**Subject:** FW: Land at Bilsham Road - Y/155/20/DOC, discharge of condition 15 lighting

Further CDC Ecology comments

**Subject:** RE: Land at Bilsham Road - Y/155/20/DOC, discharge of condition 15 lighting

BILSHAM ROAD, YAPTON			
Drawing Title: PRELIMINARY ENGINEERING LAYOUT. SHEET 2 OF 2			
Client: BILSHAM ROAD DEVELOPMENT LLP			
Scale: 1:500 @A0	Date: FEB 20	Designed: NA	
Drawn: LS	Checked: JH	Approved: GG	
Job No: 19-326	Drawing No: 19-326/010	Rev: J

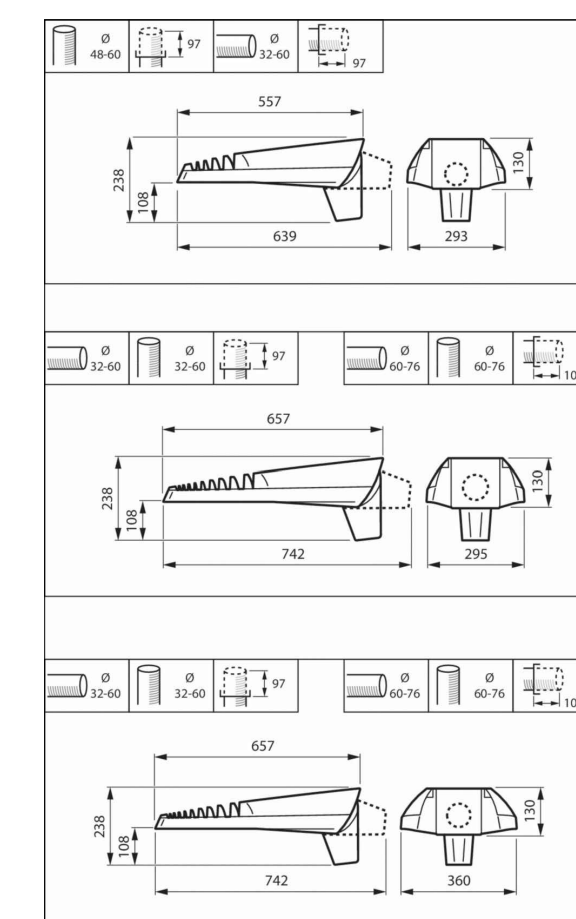
I am happy with the street lighting proposals, however there is still no information on the lighting units which will be installed on the units. Please can more information be made available for this.
